**Re: Montage 6 at 2200 O'Keefe Ave. SE
Erosion and Sediment Control Plan
Engineer's Stamp Date 2/19/24 (R16E003C)**

Based upon the information provided in your submittal received on 2/22/24, the ESC plan is approved for **Grading only**. The following comments must be addressed before it can be approved for Work Order.

GRADING COMPOSITE

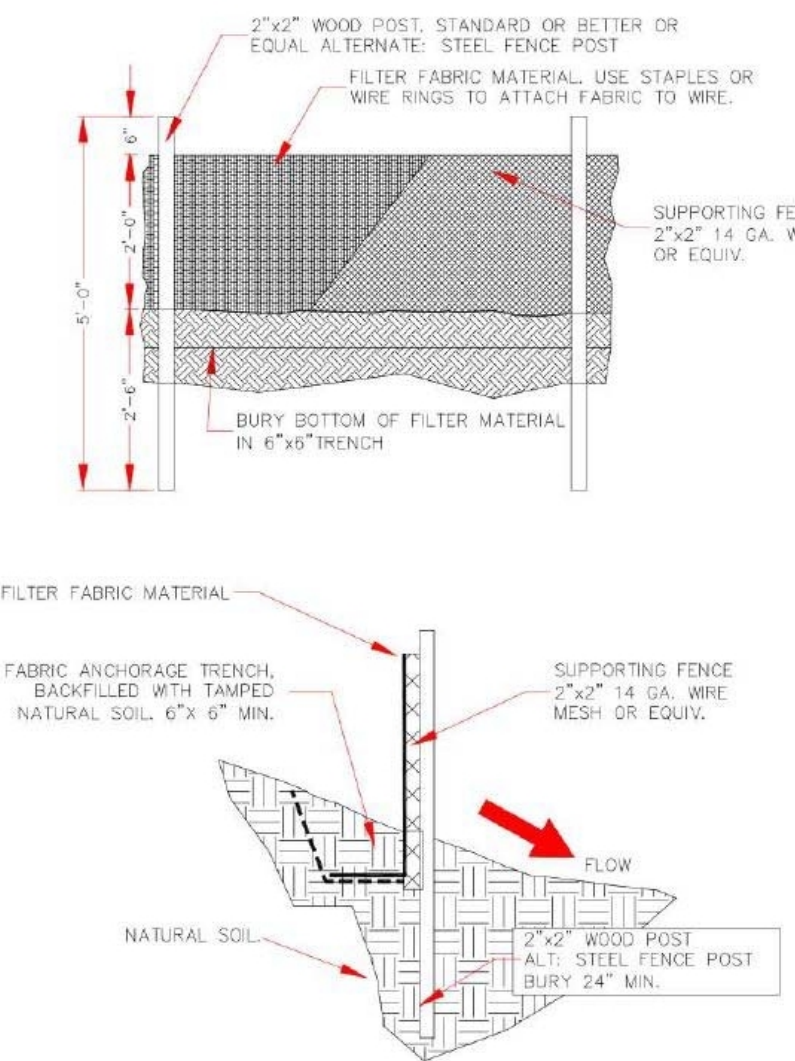
3. Define the role of SC3 as indicated by the email addresses used to certify the three NOIs for MDS Investors, LLC. If SC3 meets the eligibility conditions of CGP Part 1.1.1, SC3 must file an NOI and their area of control identified on the map in 2 above.
4. The Bernalillo County records show "Cuesta Del Oro, LLC" as the owner of Tract A-1-A-1 in Montage Unit 6, but the Operator Name on NMR10062Y is for "Cuesta Del Norte, LLC" and it must be corrected.
5. The finished grades for the retention pond on Tract 10 are missing from the ESC Plan and must be provided to match the grades approved by Hydrology.

6. Inlet Protection (IP) appears to be shown at locations where no inlets are planned, and it missing from the locations of the planned inlets. Provide IP at all of the inlet locations approved by Hydrology for Work Order.
7. The Plan can't be approved for Building Permits until separate controls are shown as part of a separate phase to prevent sediment from entering the streets during house construction on each lot. You must also differentiate between sidewalks constructed with the infrastructure and sidewalks deferred to building permit construction. You must also identify the location of all walls to be constructed at street-side yards.
8. Update the engineer's stamp date each time the plan changes.
